**SUBMISSION OF THE HISTORIC BUILDINGS AND MONUMENTS COMMISSION FOR
ENGLAND (HISTORIC ENGLAND)**

**APPLICATION BY SOLARFIVE LTD
FOR AN ORDER GRANTING DEVELOPMENT CONSENT FOR THE BOTLEY WEST
SOLAR FARM**

APPLICATION REF: EN010147

**DEADLINE 7 SUBMISSION
CLOSING STATEMENT: 10 November 2025**

Figure 3 - Central Area Masterplan Changes Animation

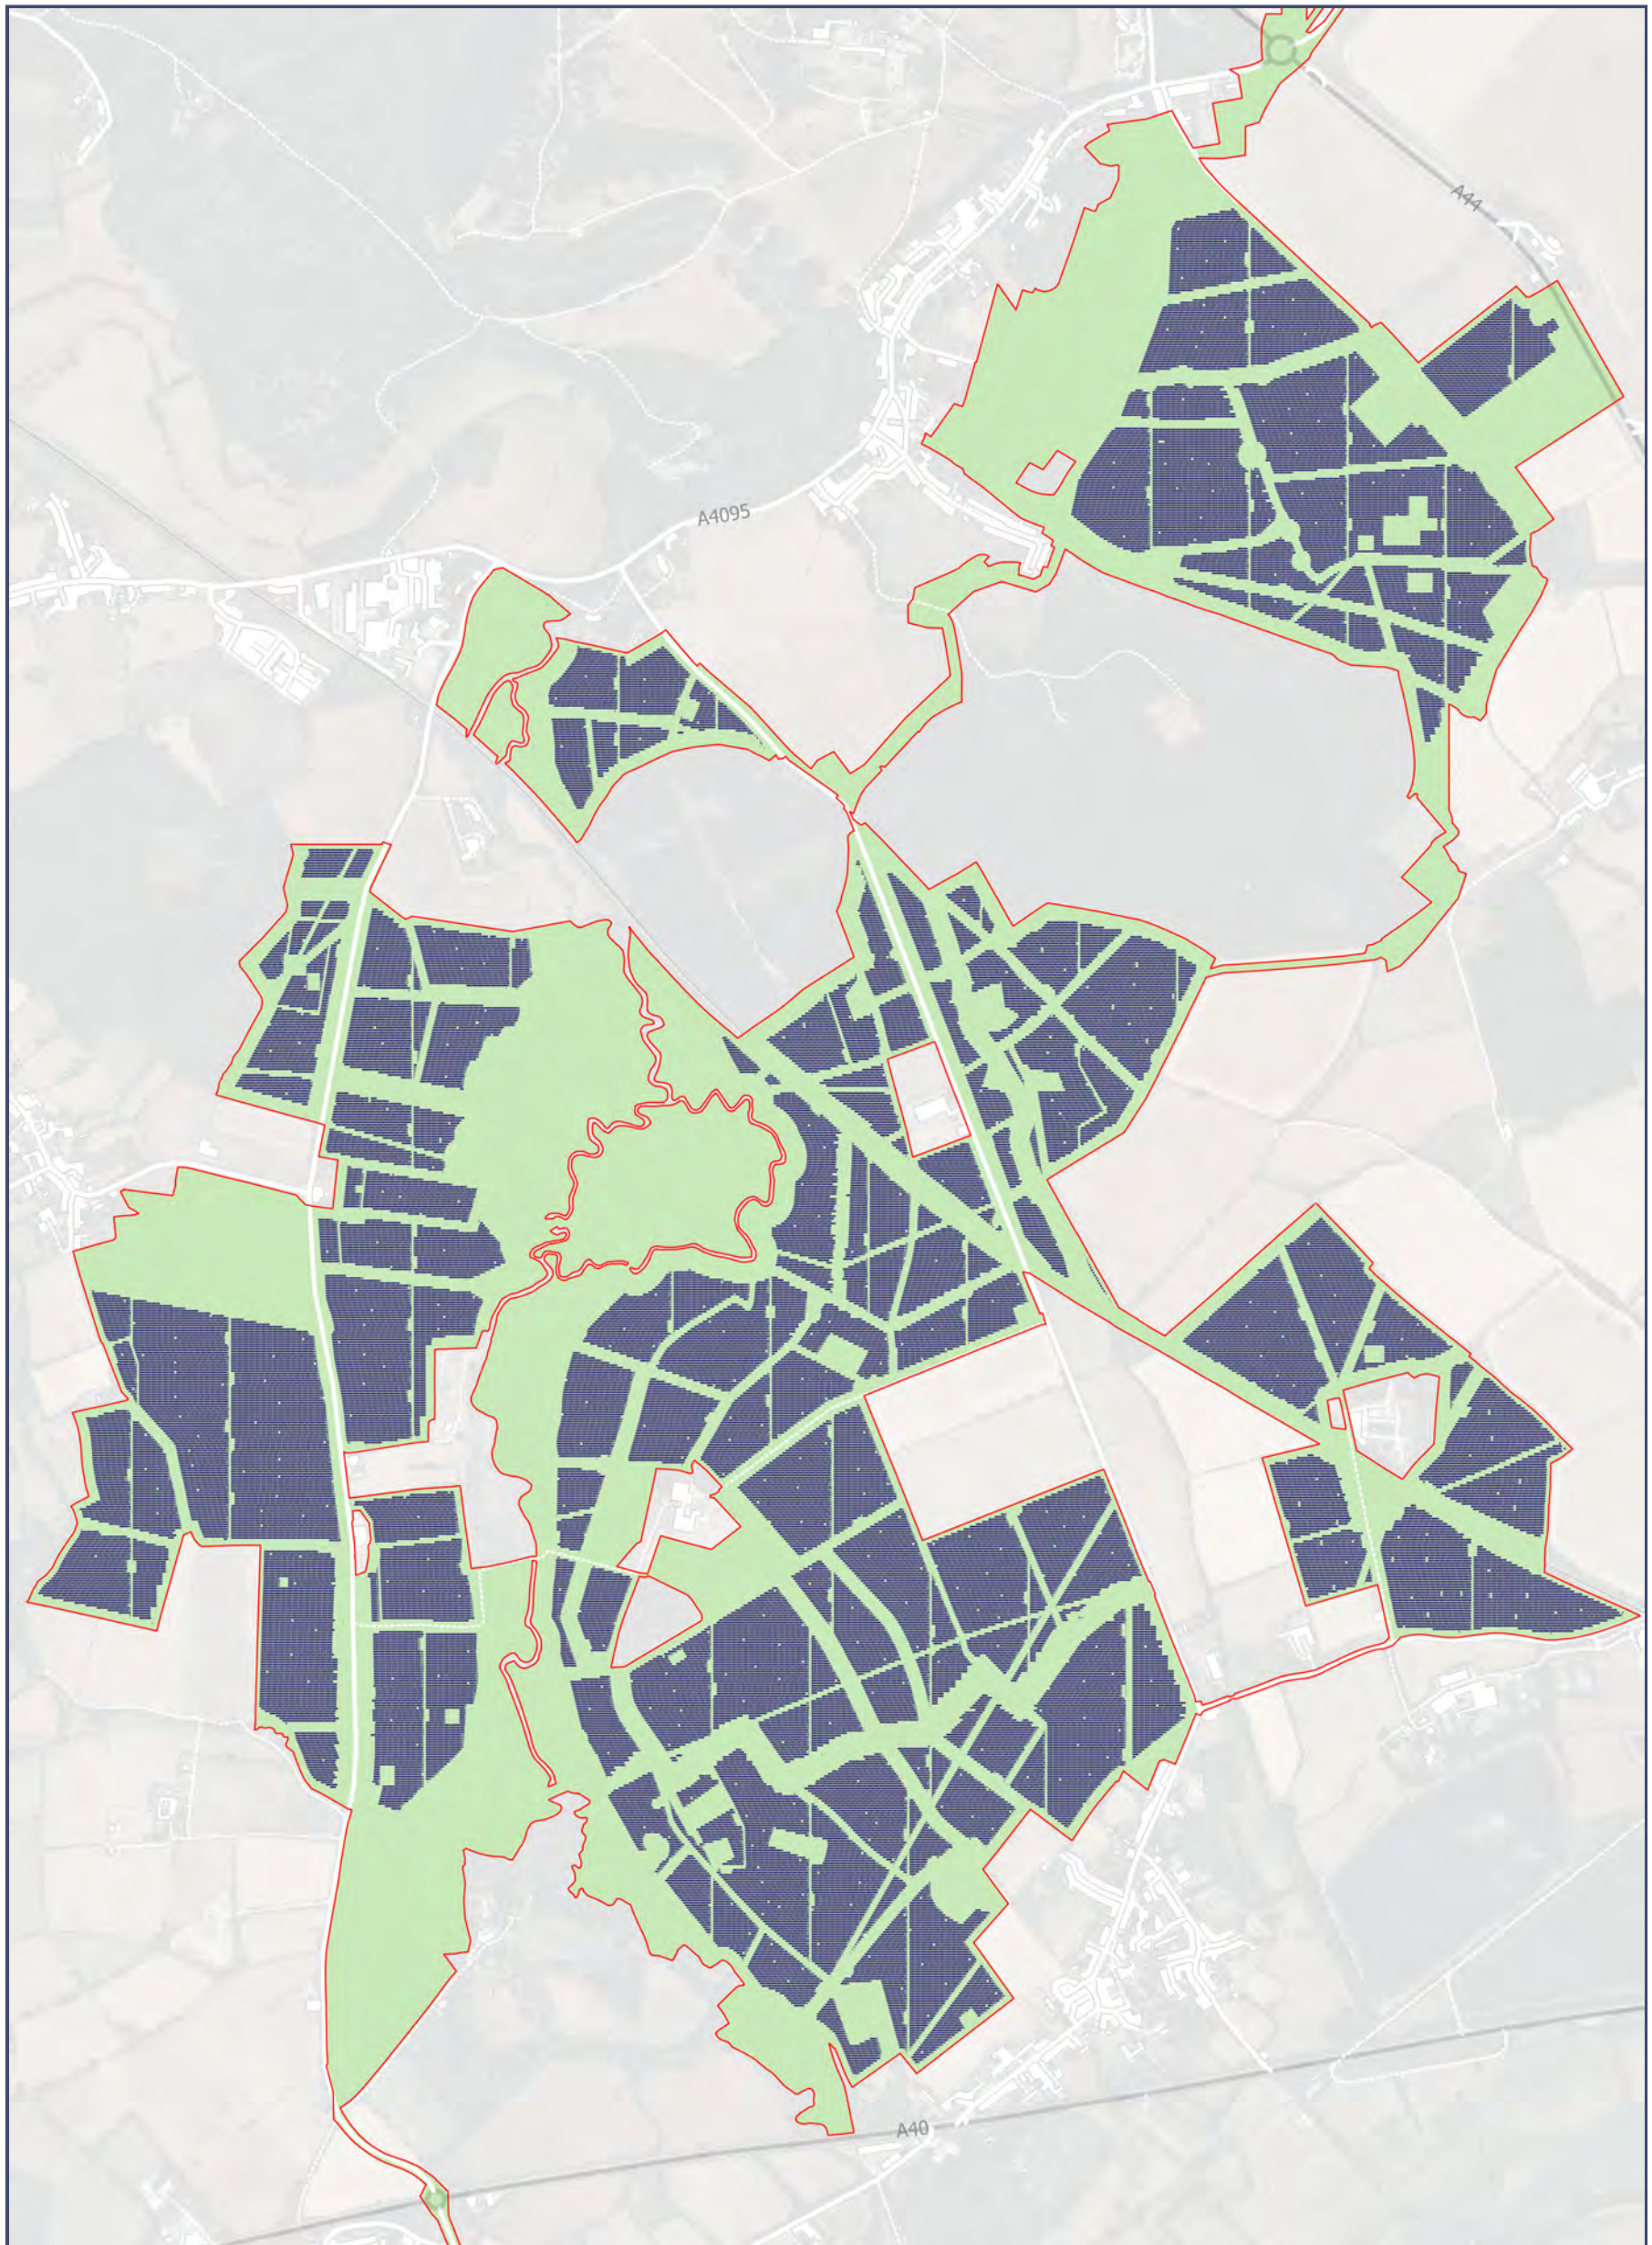
- 2.26. However, we considered that the appearance of large-scale solar arrays in field parcels 2.1, 2.2, 2.5 and 2.20-2.26, within the central section of the development, would change the character of the landscape around the WHS and the ensemble of the Palace and RPG. We noted that the "way that views from surrounding fields help provide an understanding of the park's context (which contributes to Attribute 7) would be eroded" (**REP1-086 paragraph 5.42**).

- To remove solar panels from fields 2.1, 2.2, 2.5, 2.20-2.26 to (**REP1-086 paragraph 5.56**).

- change 1: Reduction in Order Limits boundary to reduce the solar installation area southwest of Bladon, and removal of solar arrays on land east of Bladon and north of Heath Lane; and

- 2.34. We concluded that the removal of panels (change 1) appears to have minimised harm to OUV and avoided intervisibility with the WHS (**REP6-092 paragraph 2.5**). This conclusion was supported by additional photomontages (**CR2-059**) submitted in the Change 2 Request. Our Deadline 6 response (**REP6-092 paragraph 6.1**) noted that the
-

submission “confirms solar arrays would not be visible from within the World Heritage Site or from the fields we have identified as those which have a strong intervisibility and connection to the World Heritage Site.” The recommendation made in **REP1-086 paragraph 5.56** has therefore been addressed.
